Your reference: SSD-71547218

Development Application

**State Significant Development – EIS & DA Exhibition – Waste or resource management facility
8 Styles Street Kurri Kurri NSW 2327, 1//DP1309128**

The RFS has reviewed the bush fire hazard assessment, undertaken in the bush fire report prepared by Cool Burn Pty Ltd (Version 1.1 and dated 12 February 2025) to demonstrate compliance of the proposed works with relevant provisions of Planning for Bush Fire Protection (PBP) 2019.

Residual Material Processing Shed - North Elevation  
Scale: 1 : 200

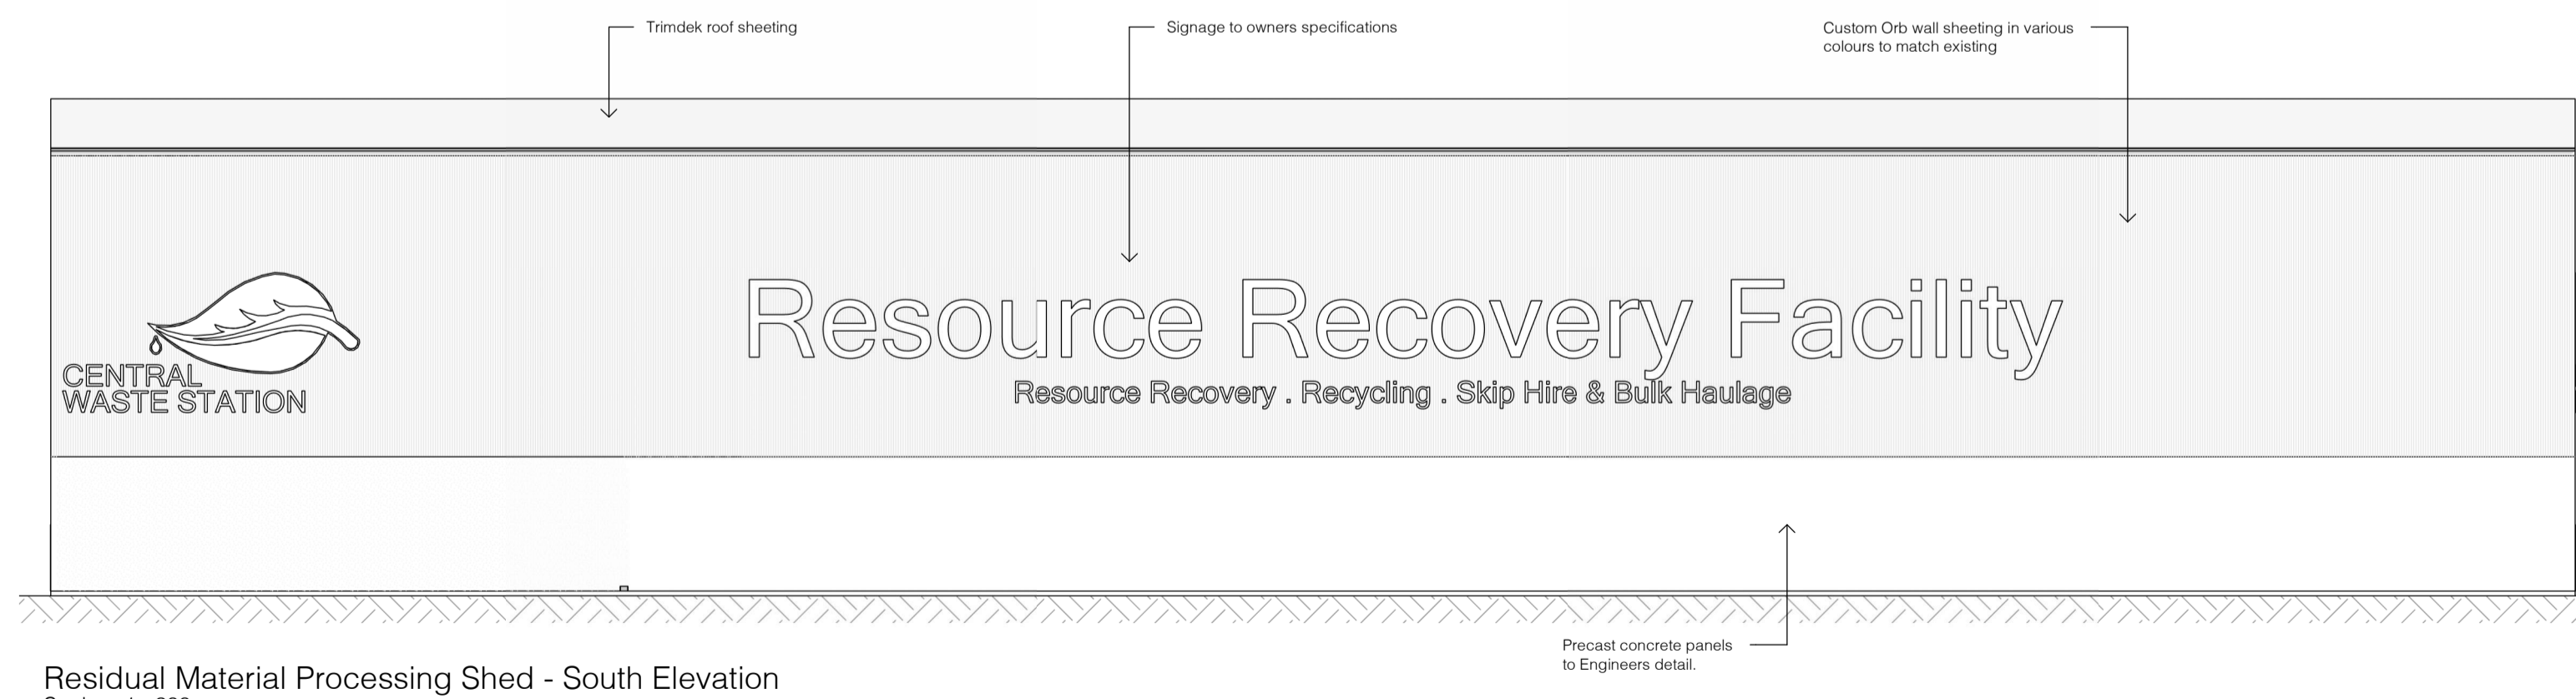
4. Proposed construction of the awnings, located over existing storage sheds, new processing shed additions (material bays) and the residual materials processing shed, must be undertaken using non-combustible materials.
